MEMORANDUM

DATE: February 15, 2024

SUBJECT: PUDSP-21-010 – Grandview Reserve (with PSSG)  
Eighth Submittal (“V11”)

GRANDVIEW METRO DISTRICT
DRAINAGE B PLAN AND PROFILE

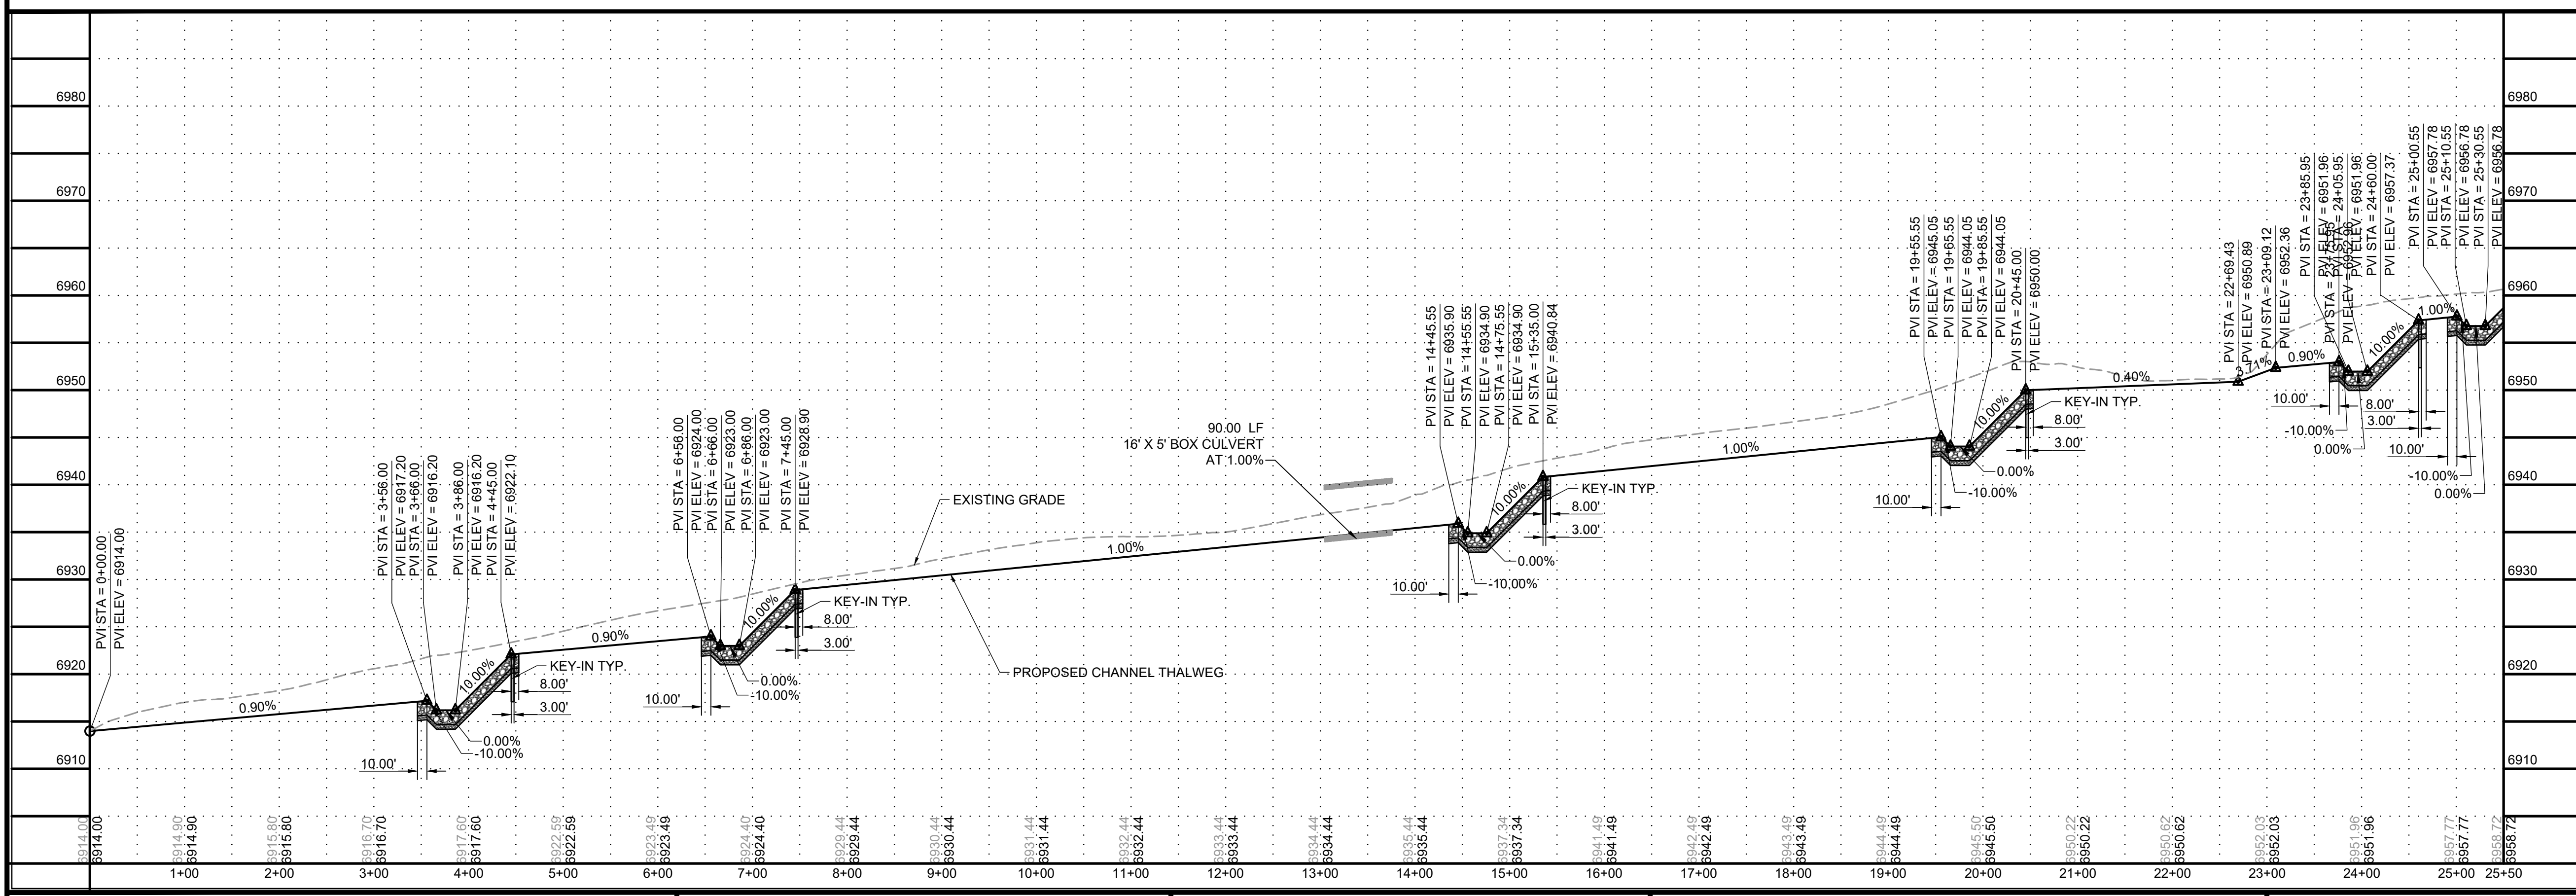
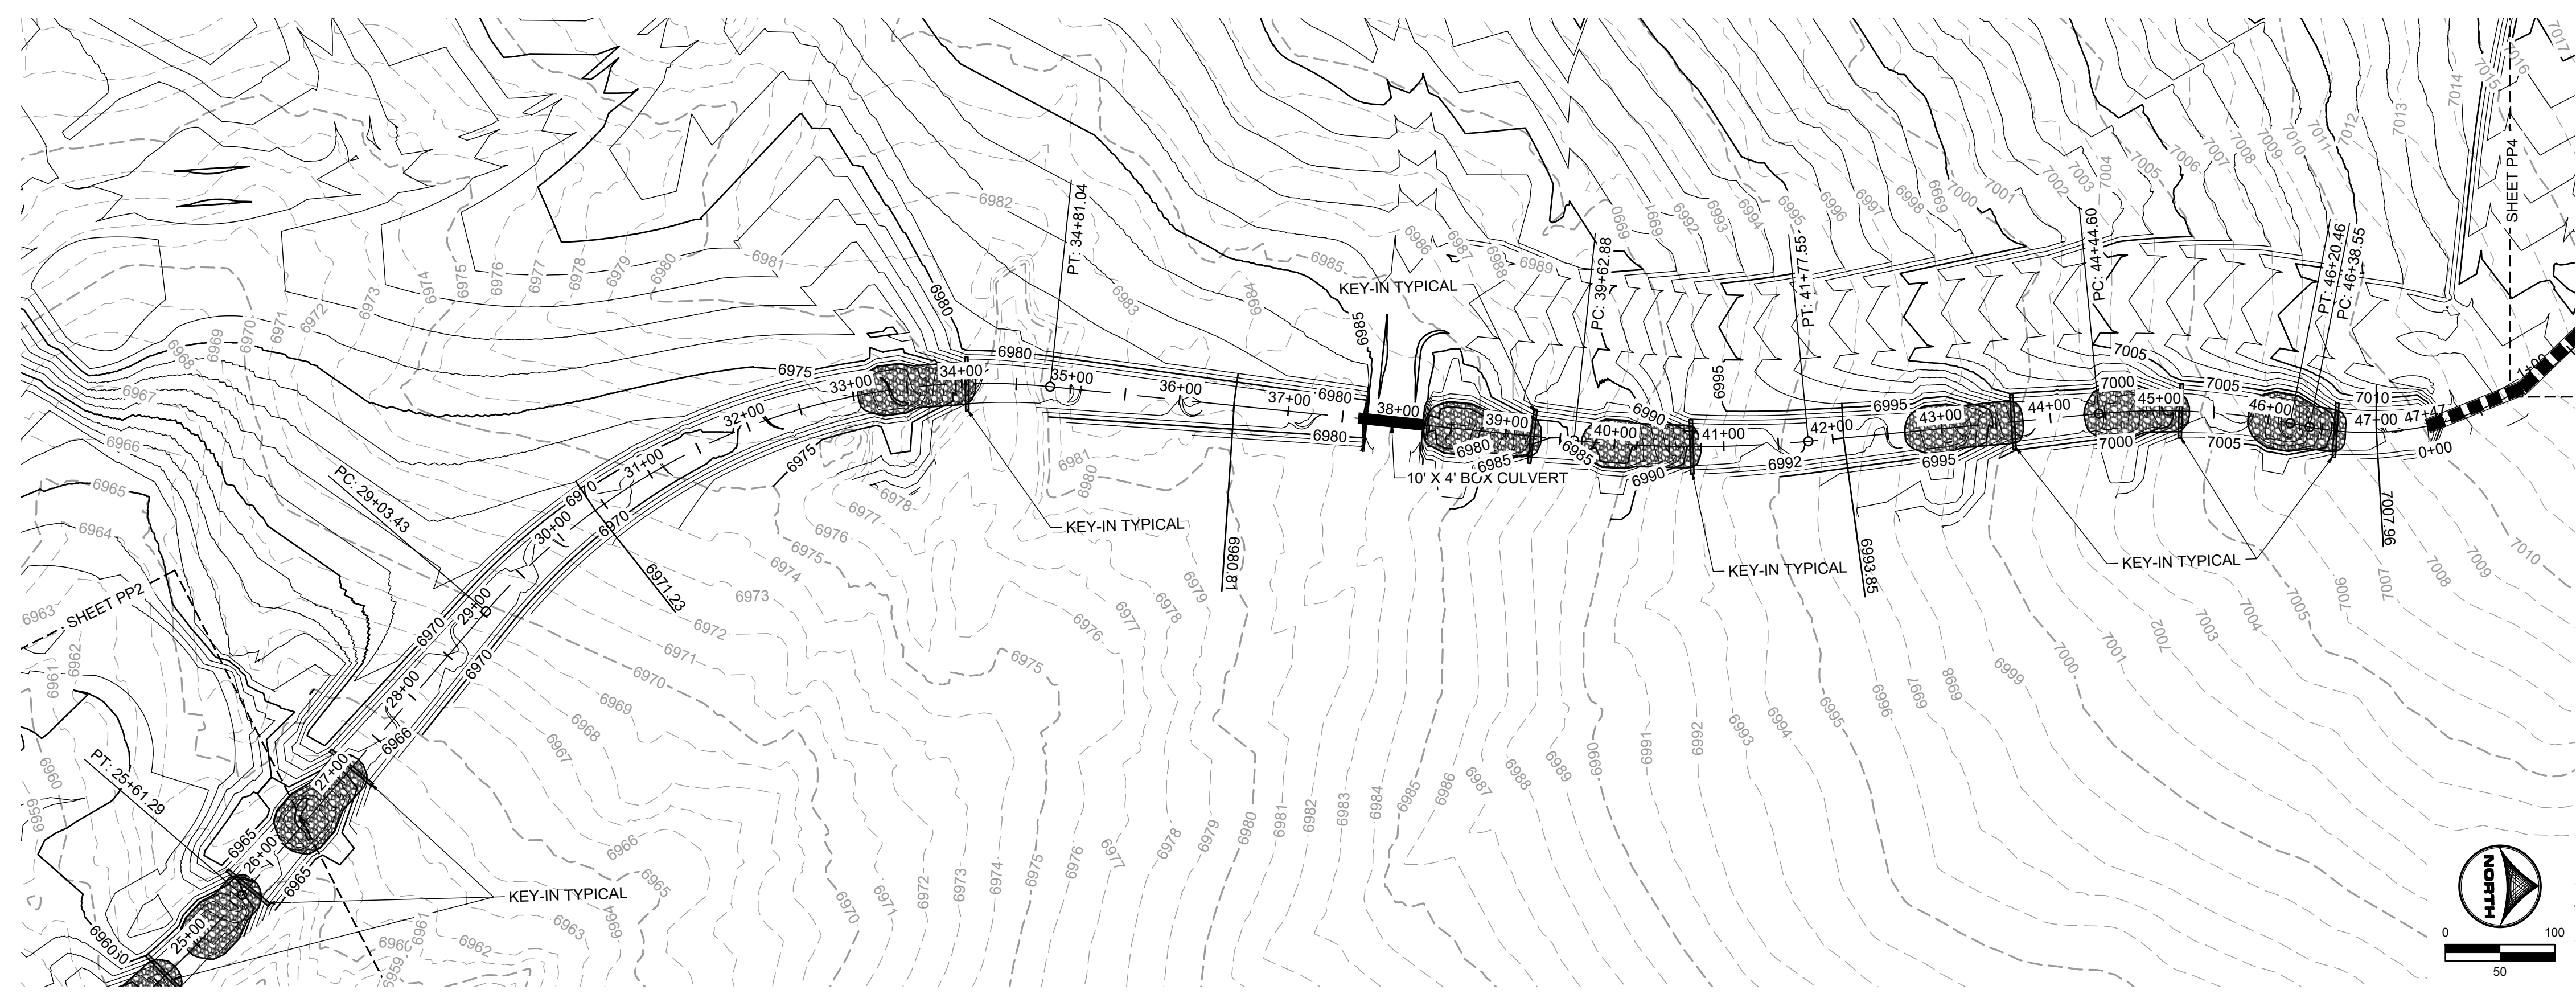
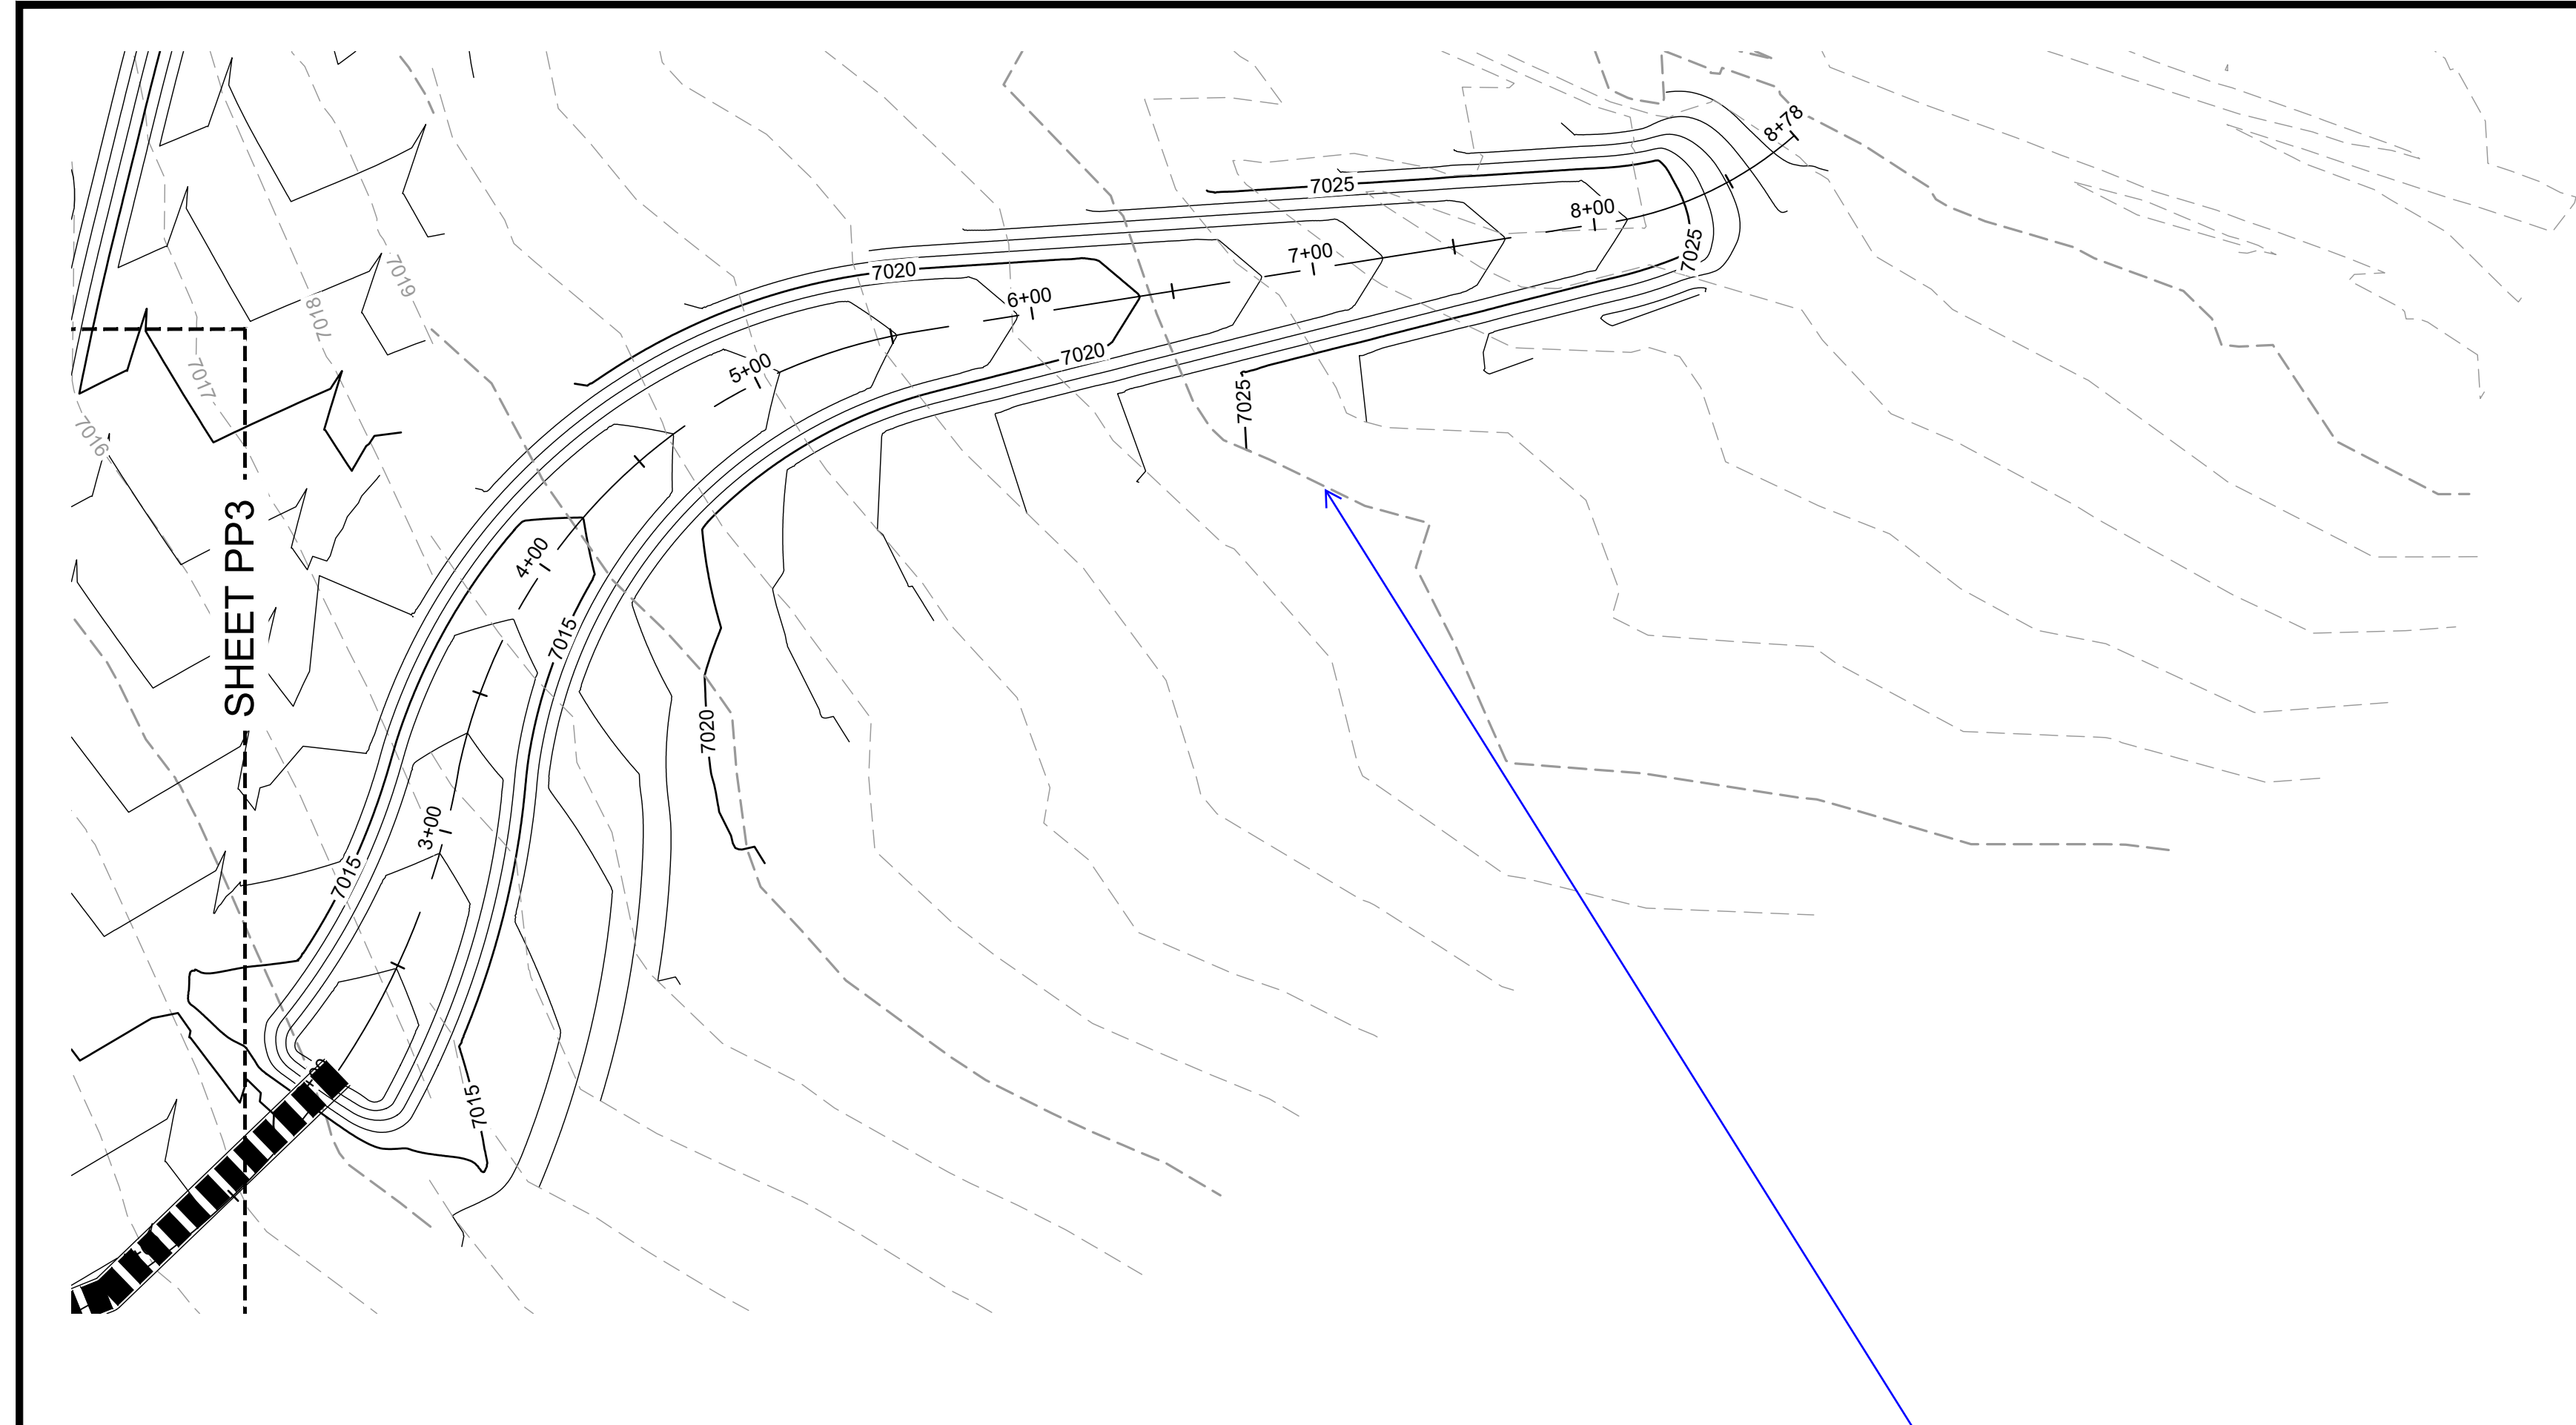
3. through 8 – Resolved.
9. Provide channel and swale cross-sections and drop/check structure design on the plan. Provide a channel plan and profile. Unresolved. Partially resolved;
